Rezoning Transportation Analysis

Petition Number: #2022-218

Date	Description
05-24-23	First Review (ME)
06-21-23	Second Review (DR)

CONCEPTUAL SITE PLAN
REZONING PETITION #2022-218

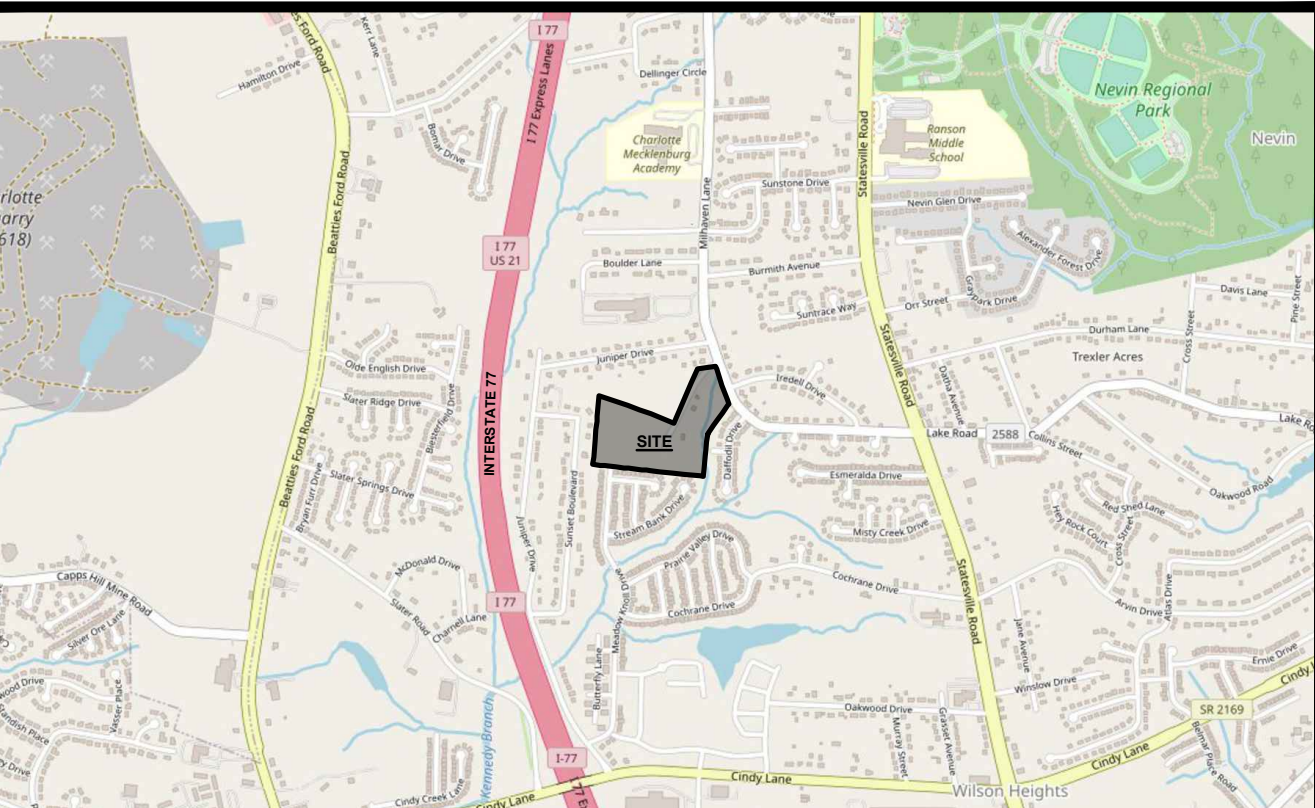
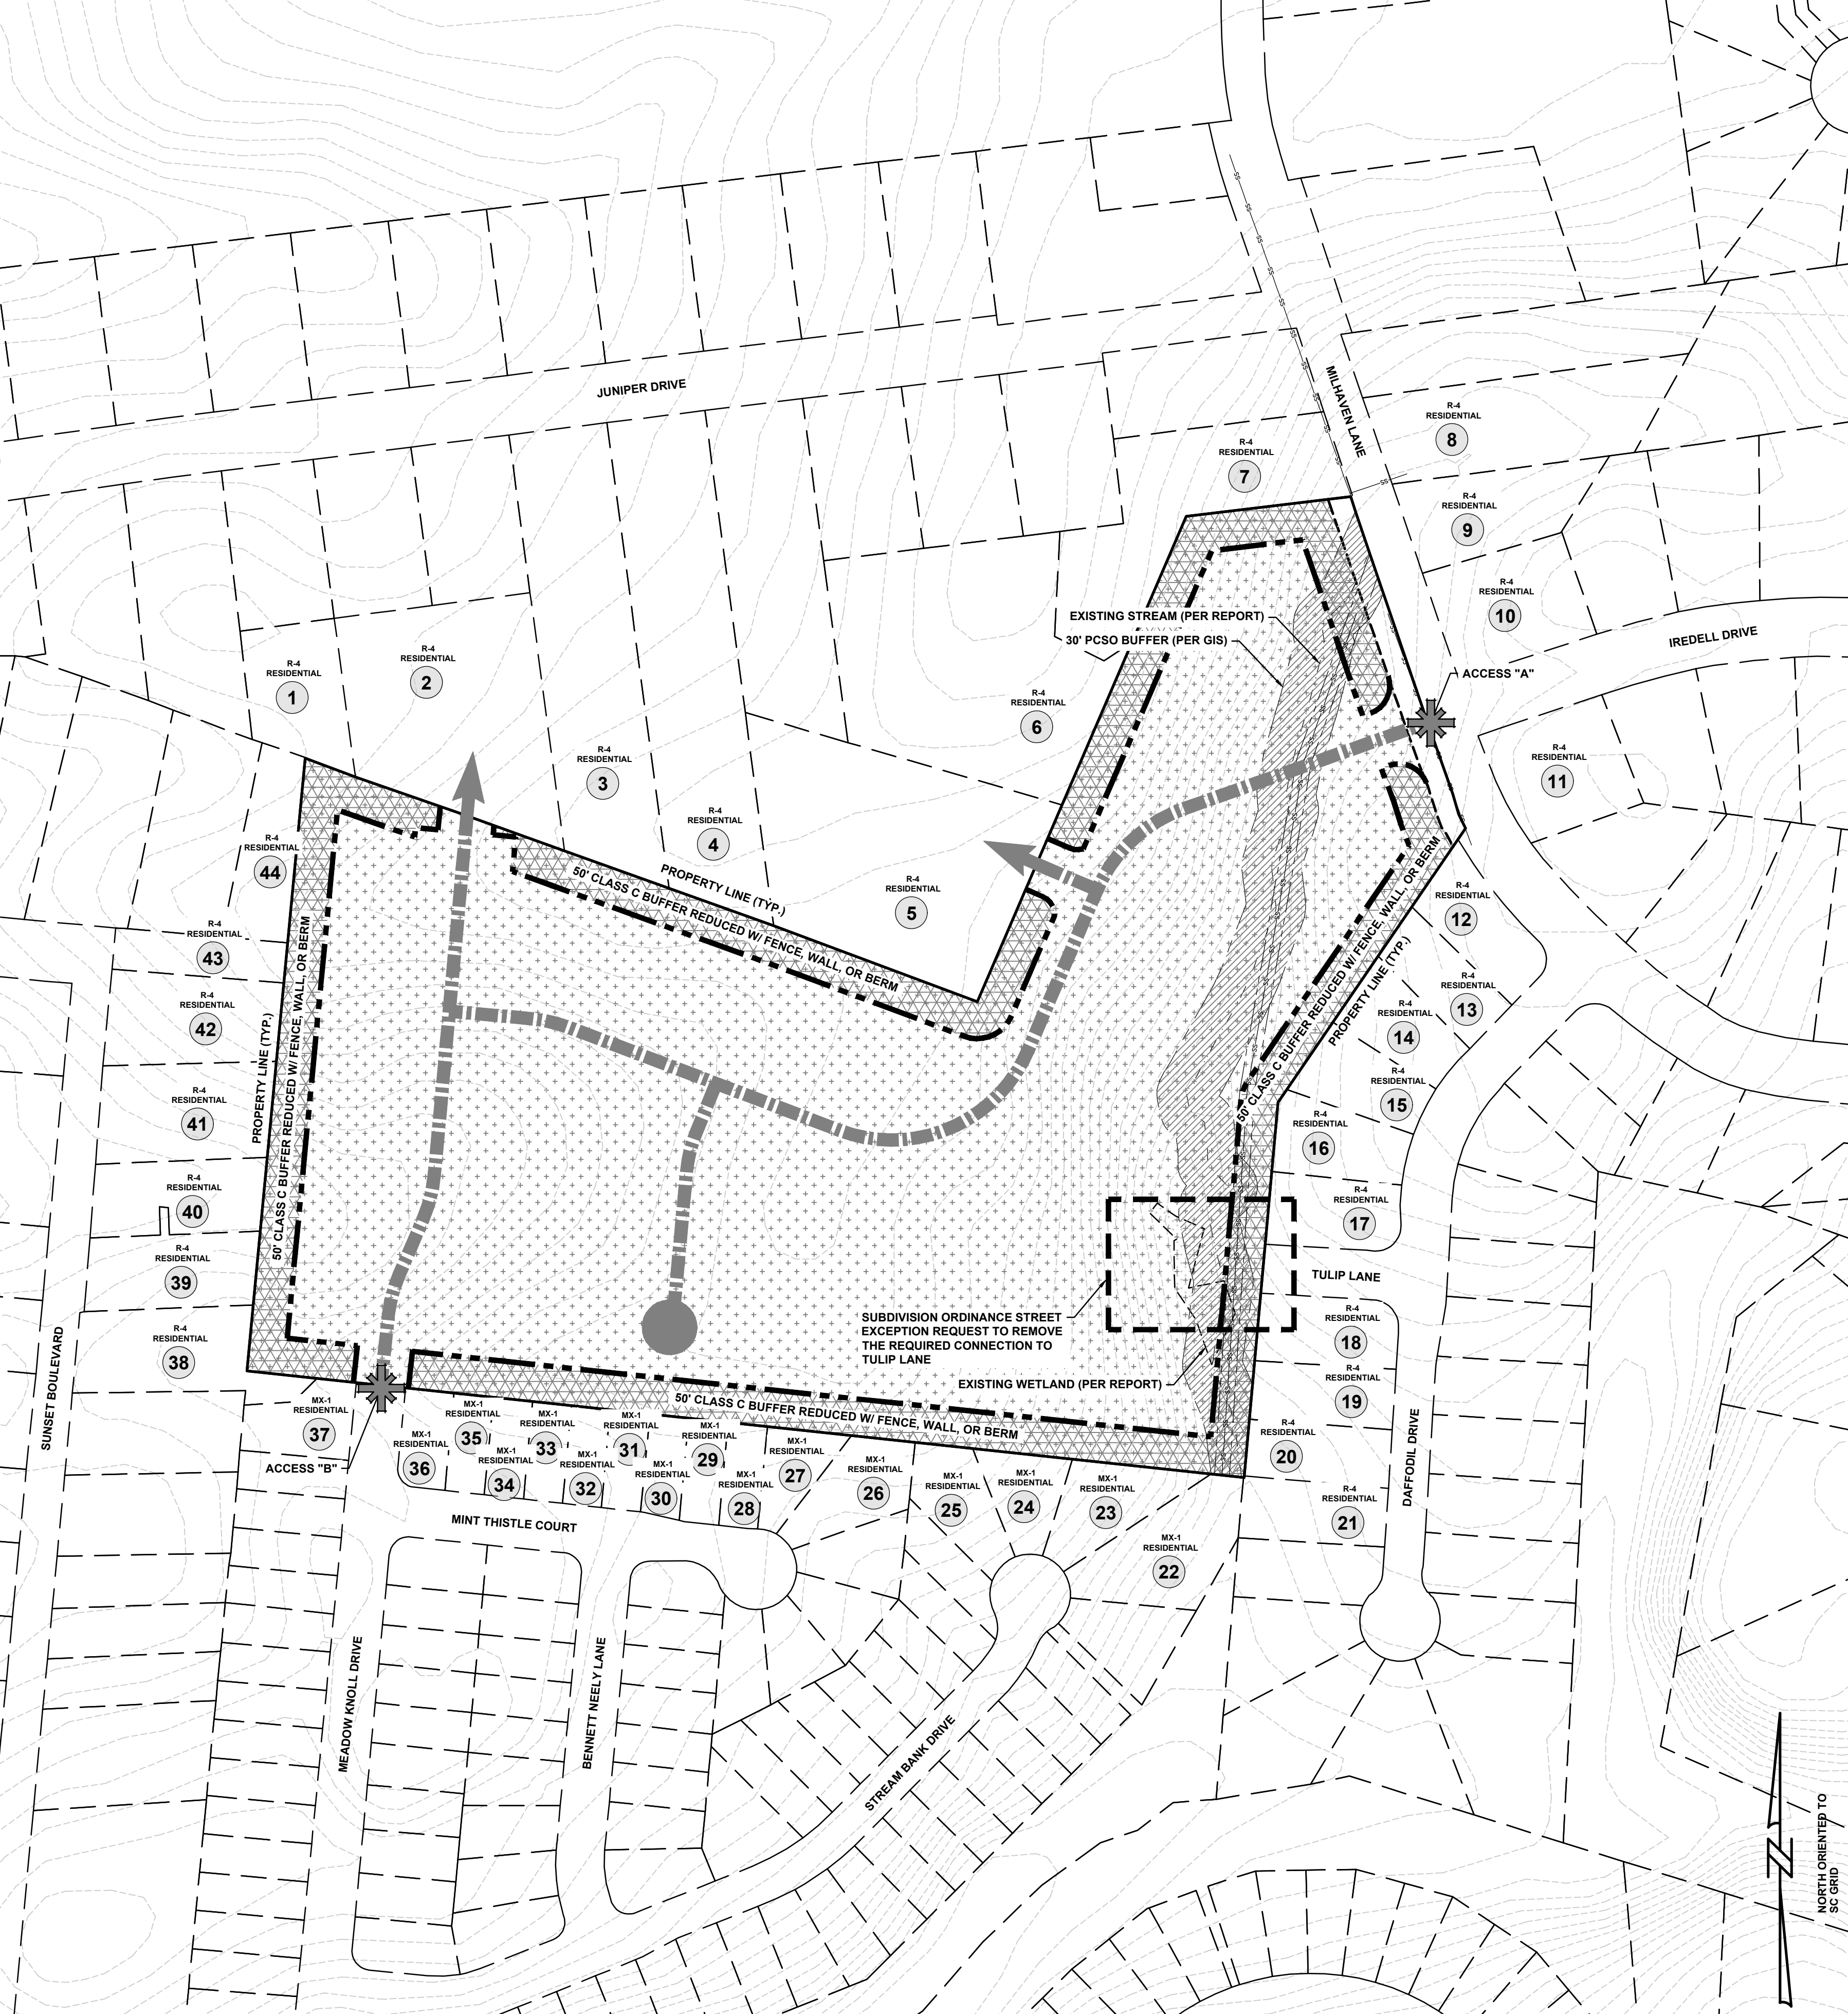
4. Revise site plan and conditional note(s) to commit to construct an 8-foot planting strip, and 5-foot sidewalk on Milhaven Lane per Chapter 19 / Chapter 20. The site plan shall label and dimension both items from the back of curb and gutter or edge of pavement.

Clarifying Comment 6.21.23: Label and dimension 8-foot planting strip and 5-foot sidewalk along internal public streets.
